Application for removal or variation of a condition following grant of
 planning permission. Town and Country Planning Act 1990.
 Planning (Listed Buildings and Conservation Areas) Act 1990

Listed Building consent . Proposed remedial work, including re pointing building with lime mortar.

Application reference number:H05-0535-13

The applicant wishes to revise the proposed layout of the scheme to create three apartments in the area currently denoted as unit 12 (postal address Number 12 Holbeach house) .

PROPOSED GROUND FLOOR PLAN

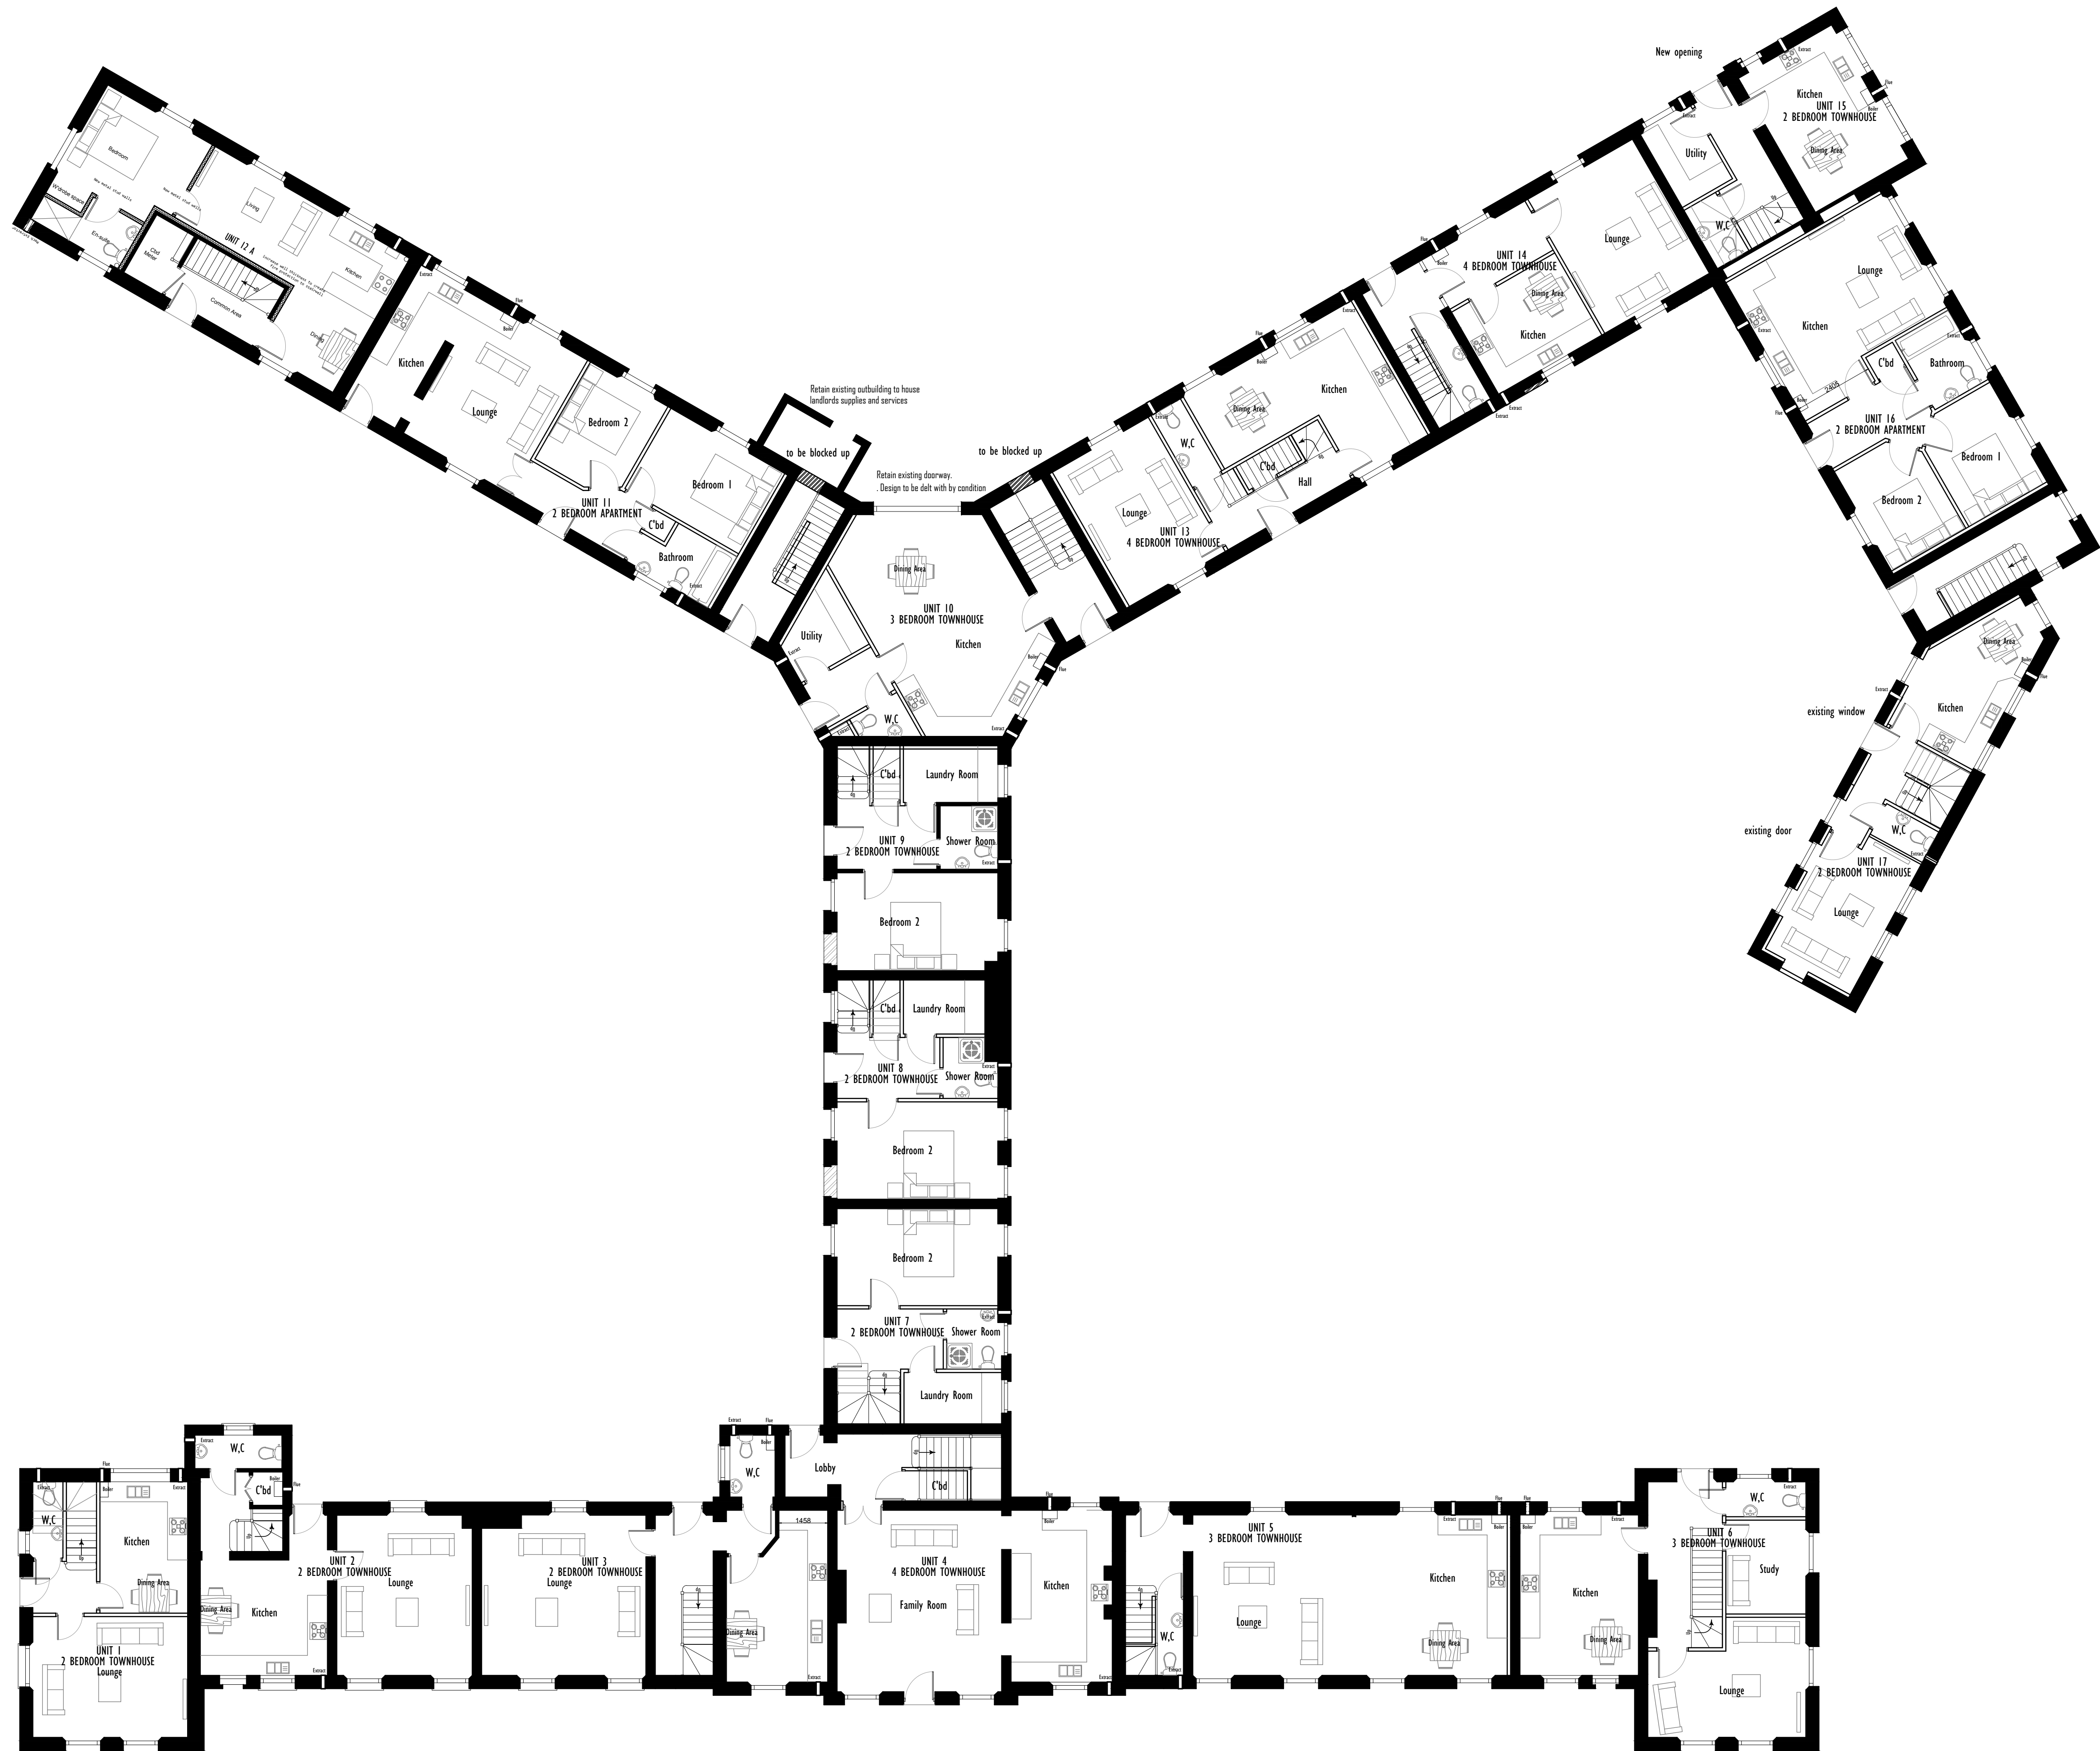
Unit 12 would be revised to incorporate a 1 bedroom apartment on the ground floor, a 1 bedroom apartment on the first floor and a further 1 bedroom apartment on the second floor.

Drawing number IDHH/RW/13/001 to be revised to IDHH/RW/13/001 REV B.

PROPOSED FIRST FLOOR PLAN

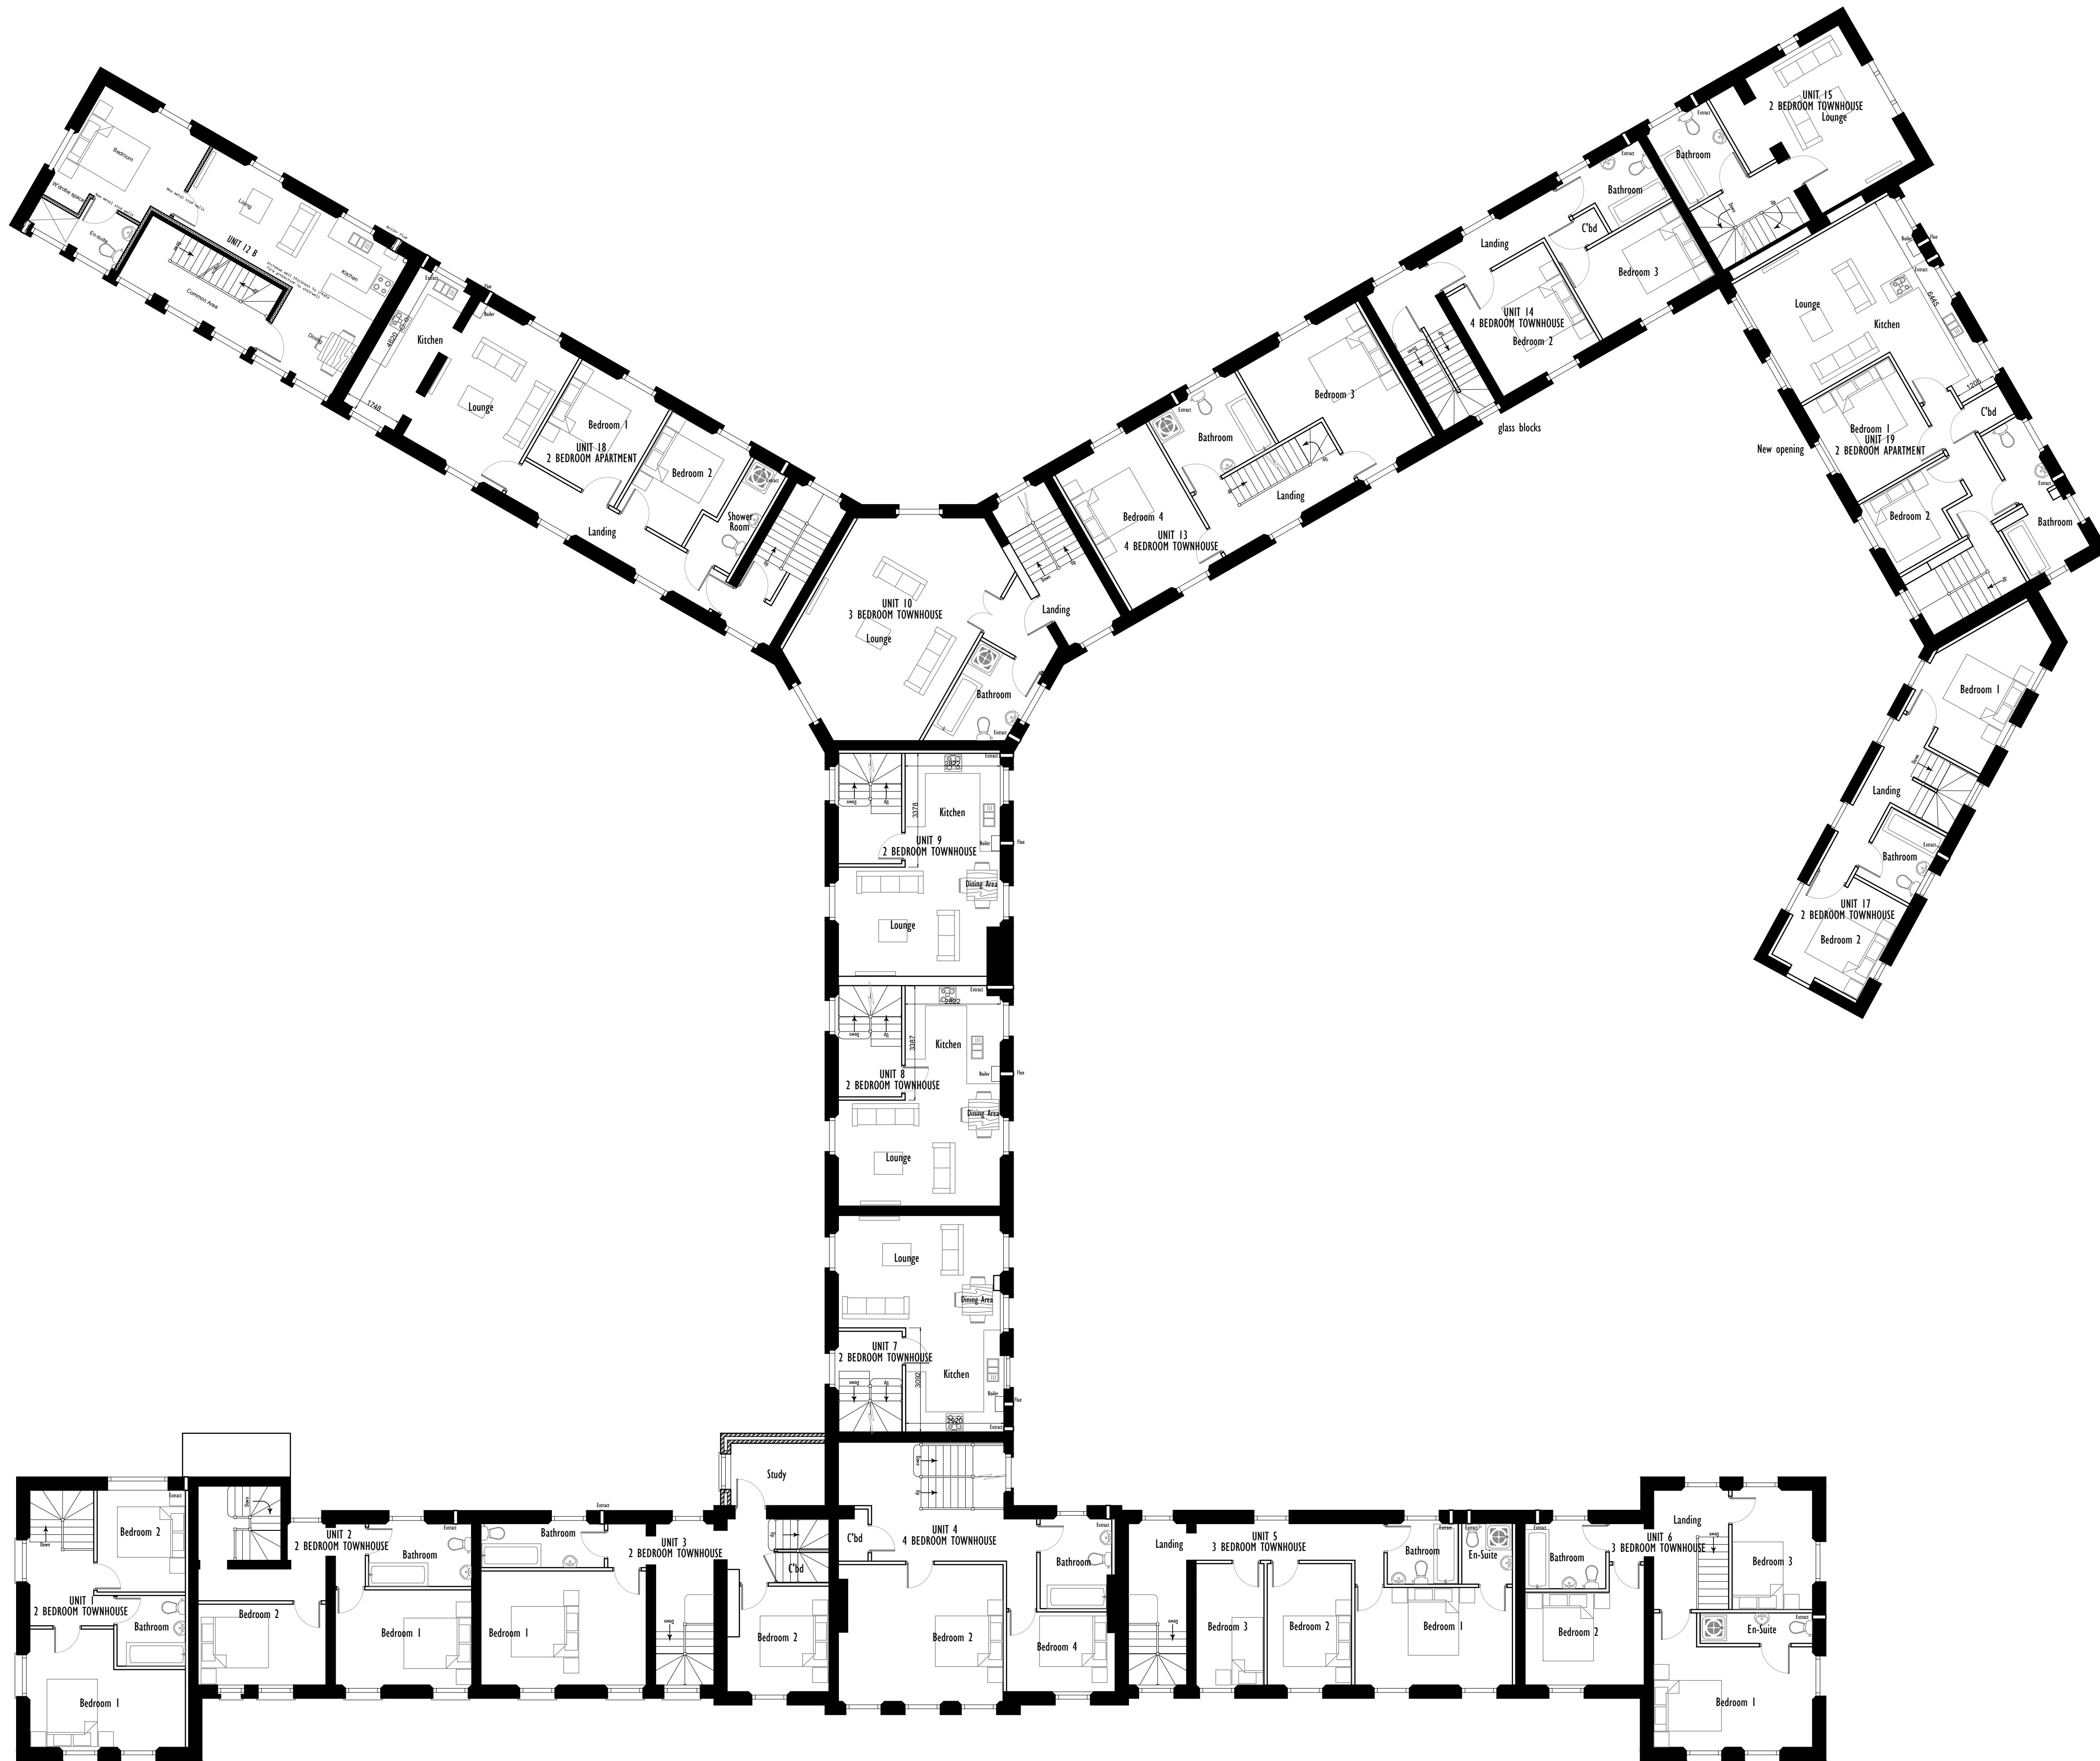
Drawing number IDHH/RW/13/002 to be revised to IDHH/RW/13/002 REV A.
